Ref. 10301/sjr/02  
Date. 16<sup>th</sup> October 2024

**Application 3/2024/0726**

**Location: Shackleton's Garden Centre Ltd, Clitheroe Road, Chatburn, BB7 4JY**

**Proposal: Proposed two-storey extension to rear and re-modelling of home and garden centre, including additional indoor and outdoor retail space and increased cafe area and play area**

Title: PROPOSED DRAINAGE GENERAL ARRANGEMENT SHEET 1 OF 2

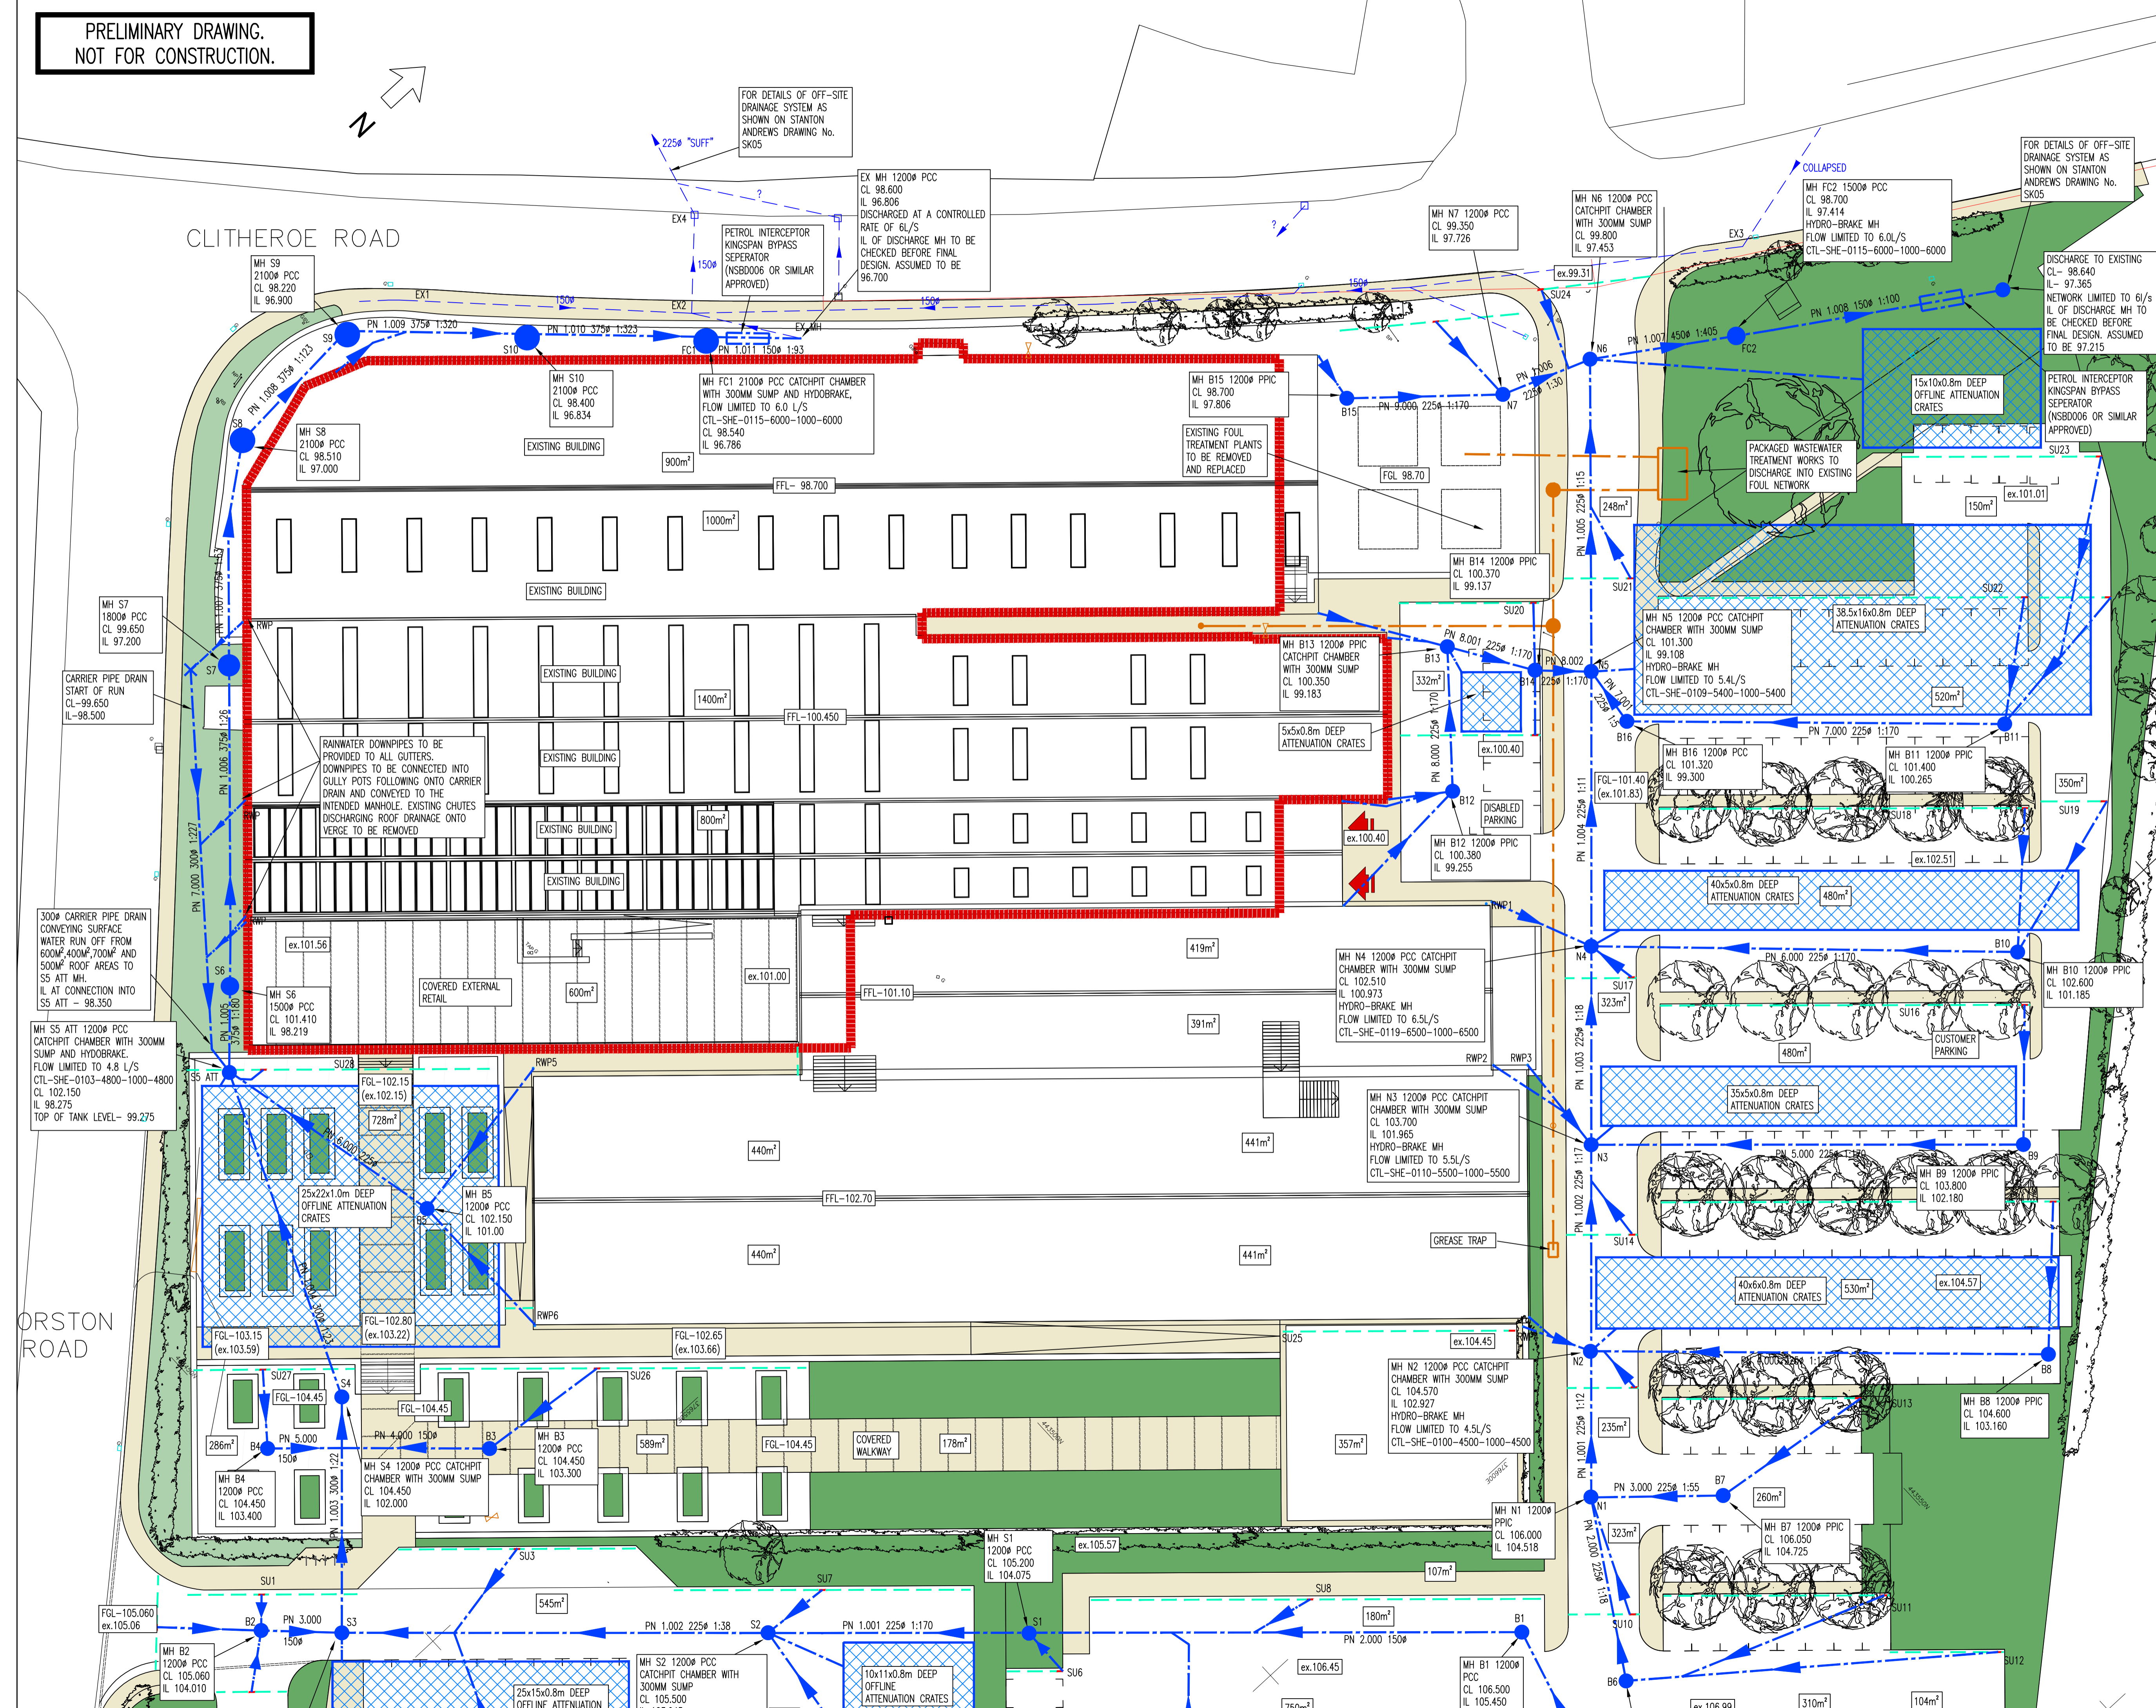
*Following a long history of flooding of the highway on Clitheroe Road, in 2021 Lancashire County Council carried out an investigation and identified a blockage 5m north of manhole EX4 (manhole reference taken from drawing 'Reid Jones Partnership 10301-101-P5 Proposed Drainage GA Sheet 1 of 2'). Manhole EX4 was full of silt. The blockage lies beneath third party land and is causing the system to silt up and flood the highway. The site was visited again in June 2023 but the manhole EX4 was unable to be accessed due to a parked car, there was water bubbling up from the concrete yard and it was anticipated that the same problem was evident. The surface water drainage from the site will be connected into this system.*

*Further evidence is needed to demonstrate, that these systems are in a sufficient condition and have sufficient capacity to accept the runoff generated by the proposed development, without resulting in an increased risk of flooding the highway. If the previously identified blockage has not been rectified, then the proposal is likely to result in an increased risk of flooding to the highway which the Highway Authority would raise an objection to on highway safety grounds.*

- A survey of the existing drainage system immediately outside the Shackleton's site was carried out and submitted in support of the planning application.
- The surface water drainage from the existing site already connects into this system.
- Surface water runoff from the existing buildings facing Worston Road, prior to development taking place, is discharged directly onto Worston Road and creating a flood risk on the carriageway. The drainage proposal collects all surface water runoff from the roofs of the buildings on Worston Road into the proposed surface water drainage system, which will attenuate flows from this part of the site to 6.0 l/s. There will therefore be no direct discharge of surface water from the developed site onto Worston Road.

Could we please point out that as the downstream drainage system lies outside of the blueline and is not under the control of the applicant, the responsibility for the maintenance of the drains lies with the riparian owners. If works essential to keeping the system functioning are not carried out, then Lancashire County Council has the powers of enforcement under Section 25 of the Land Drainage Act 1991 as amended to ensure that the work is carried out.

In view of the above, we request that Lancashire County Council Highways recommend the discharge of Condition 17 relating to surface water drainage.
